Natural England's End of Examination Position on Marine Processes

The construction and operation of Hornsea Project Four Offshore Wind Farm, located approximately 69 km from the East Riding of Yorkshire in the Southern North Sea, covering an area of approximately 468 km².

Planning Inspectorate Reference EN010098

10th August 2022

Figure 3: 1979 and 2011 bathymetries of Smithic Bank (top and middle) and a comparison of the 1979 and 2011 bathymetries (bottom).

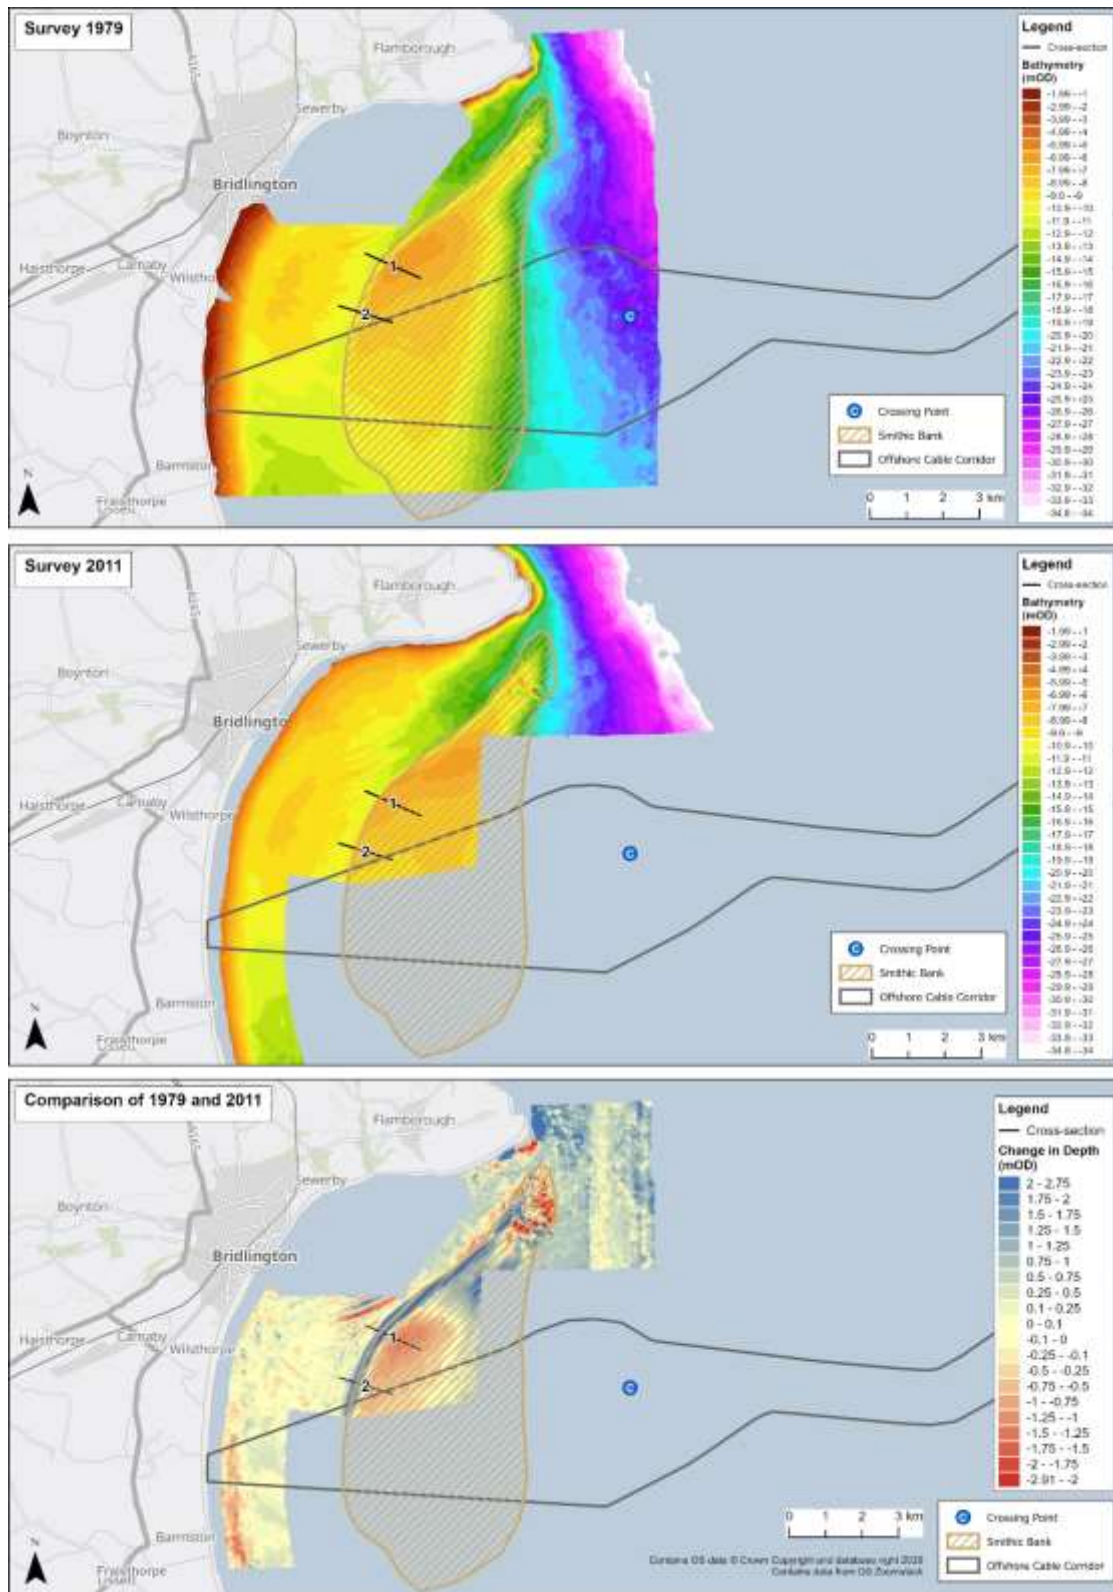
The comparative study of bathymetric data presented in the report shows a general trend of lowering of South Smithic and the westward migration of the western flank of the sandbank. However, we note that there is no estimate of sandbank volumetric change over the time periods analysed. This would be useful as it would provide some indication of the volume of sediment being lost from the sandbank over time and, therefore, we would advise that this analysis be carried out. Moreover, whilst we are content that the data shows evidence of bedform asymmetry across North Smithic, there is insufficient evidence to allow comparison of individual bedforms between survey years and, in turn, assess their migration directions and rates.

Figure 17: Indicative sediment transport pathways (red arrows) across Smithic Bank (derived from bedform geometry) and the position of the boundary between ‘Flamborough Influence’ and ‘Holderness Cliffs Influence’ of Pye et al. (2015) (blue line).

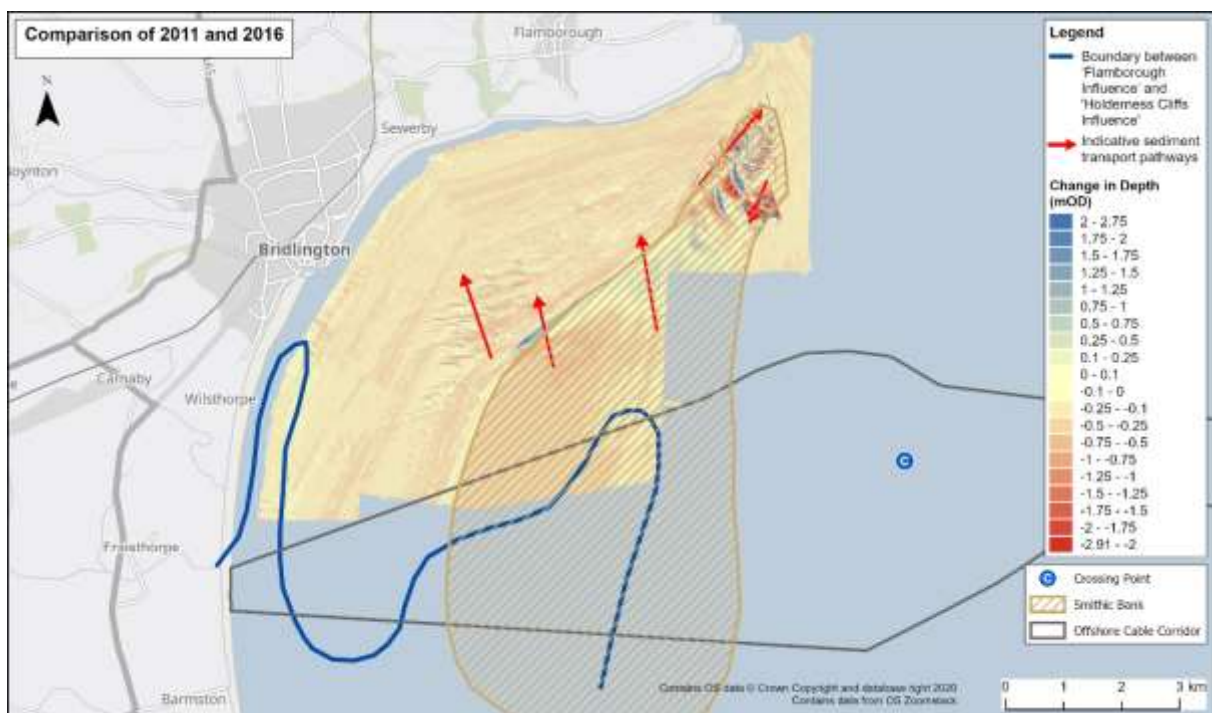
Section 2.3.4.1 states that “rotational sand transport around Smithic Bank is likely to be contained within Bridlington Bay, with little or no transport from this source south along the Holderness Coast.”. However, Pye et al (2015) showed that sediment from the southern parts of Smithic Bank exhibit a high degree of similarity to beach sediment from between Fraisthorpe and Skipsea. Moreover, Section 2.3.3.2 in the Supplementary Report discusses the sediment accumulation due to the clockwise movement of the tidal gyre, yet Pye et al. (2015) also provide evidence of a net sediment transport pathway driven by anticlockwise residual circulation from the nearshore towards the southern part of Smithic Bank. Therefore, whilst it is acknowledged that Smithic Bank is at the centre of a tidal gyre, and that the sandbank(s) acts as a sediment depository, it cannot be inferred that this is a predominantly self-contained system without supporting evidence. This is a complex sedimentary system and could potentially be a semi-enclosed system, or even a dynamically leaking system.
